**Third Party Appeal of Planning Application Reference 25/60750 for quarrying and related activity**

**Cartron, Belclare, Co. Galway**

25/60750 - PERMISSION for continued use of the existing quarry (granted under Planning Ref. File No.: 06/2275 and ABP Ref.: PL07.222783), including drilling, blasting, crushing, processing, and stockpiling of materials within a total site area of 15.09 hectares to the permitted depth of 33m OD. Continued use of existing permitted structures and facilities, including: weighbridge and wheelwash with side and overhead spray bar, office and staff facilities building and carpark provision (Ref. 17512). Asphalt plant (Ref. 15104), concrete batching plant (Ref. 20419), maintenance shed (Ref. 141295), aggregate shed, ESB substation (Ref. 191964), crushing and screening plant, and stock bays (Ref. 062275 & 21442). Associated site infrastructure. Construction of a new quarry storage yard (c. 1.09 Ha.) to the east of the existing quarry. Relocation of the existing permitted sheds (Plan Ref File No. 21442) to an area beside the proposed storage yard area. Importation of soil and stone (both waste and non-waste) for site restoration purposes and selected const

Section A-A

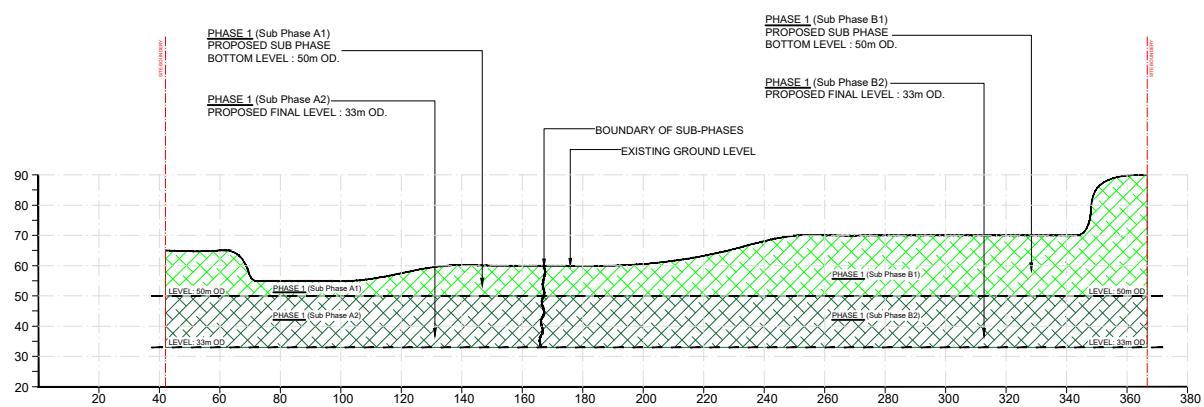
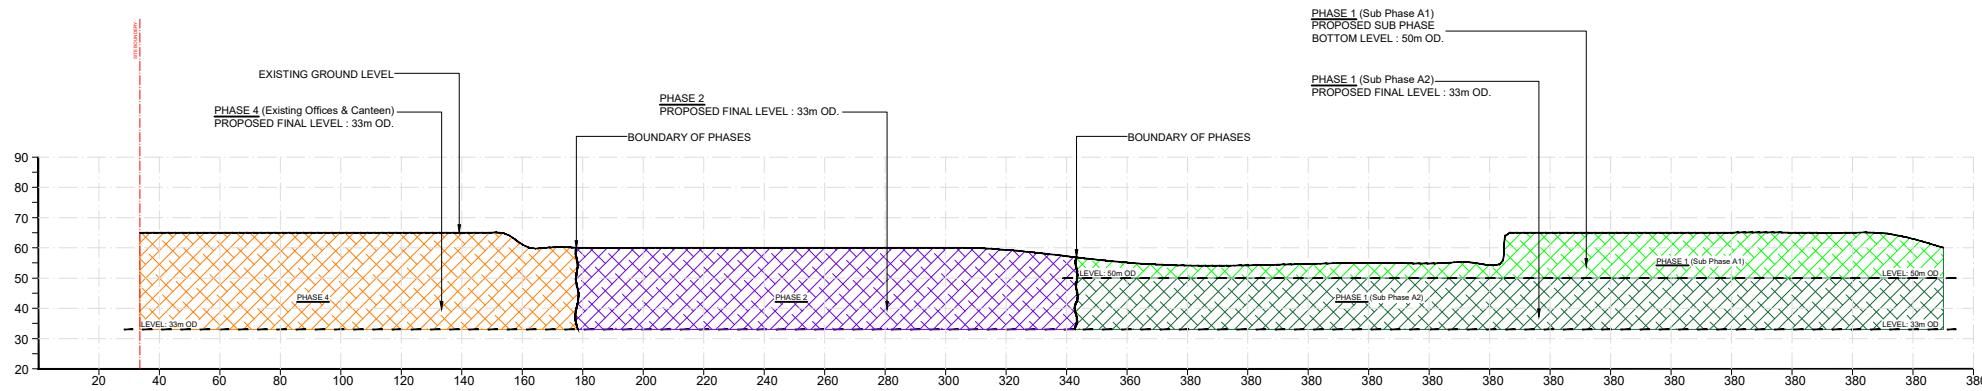
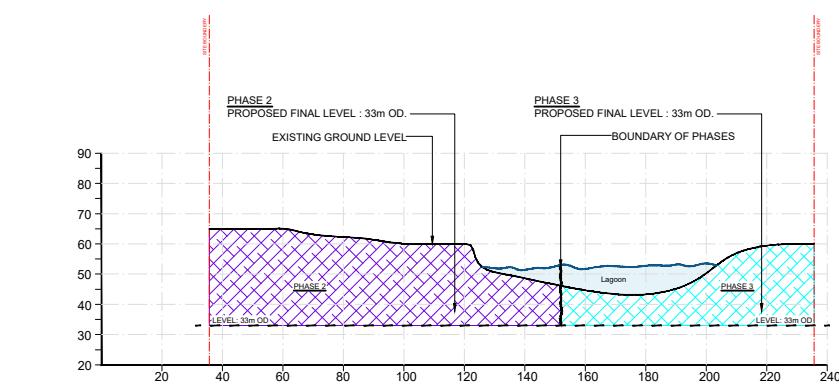
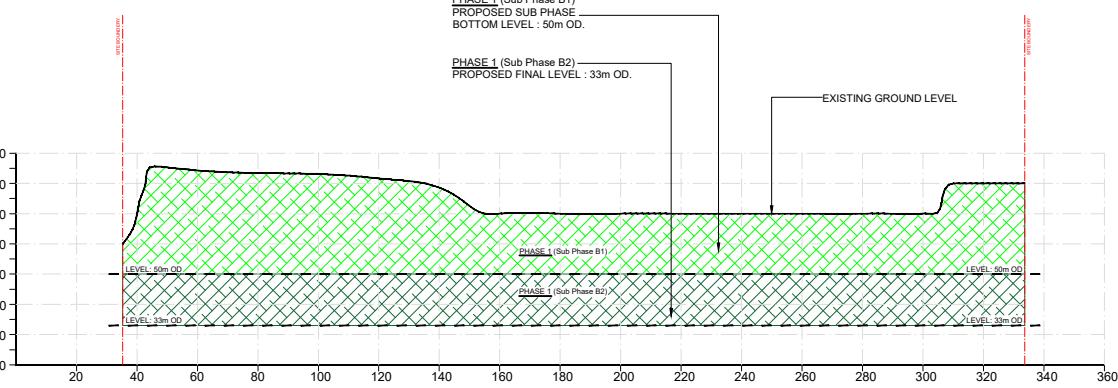
The application states, and cross section drawings show, that the 'permitted' depth at the quarry is 33mAOD. Given the calculated water levels referenced above, upon the deepest sinking, works would be below the maximum and average groundwater levels in the vicinity, thereby creating the potential for drawdown and local supplies and potential contamination of the underlying aquifer which is classified as a Regionally Important Aquifer,
